RE: The Sutherland Hospital Operating Theatre Upgrade (SSD-11099584) – response to draft conditions RFI

I refer to your letter dated 29/09/2021 in relation to SSD 11099584 for The Sutherland Hospital Operating Theatre Upgrade development. Please find our response to your queries below:

1 WEST ELEVATION SCOPING
1 : 100

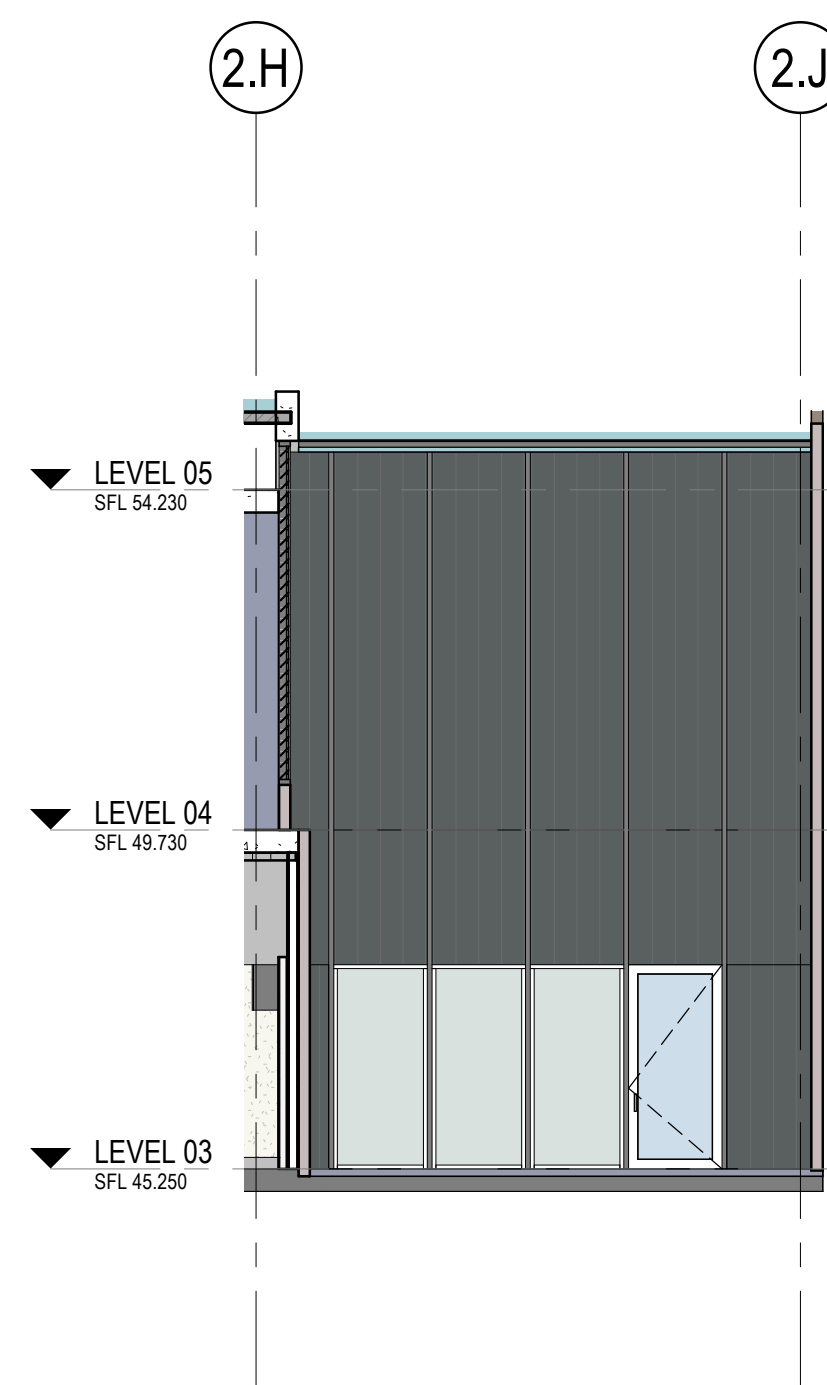
- *confirm the intended use of the Level 2 room located to the south of the existing fire stairs.*

The area south of the existing fire stairs is unallocated (ie out of scope) and will be shell space. Note that, however, 4 x windows are provided to this façade for the amenity of future users (use being subject to appropriate planning approval). To provide additional clarification, please find the attached drawing 10192314-HDR-AR-DG-150600[2] - SCOPING ELEVATION – WEST, bubbled to clarify the inclusion of windows to the façade of the space south of the fire stair as noted in Architectural Drawing HDR-AR-DG-150200 submitted under this application.
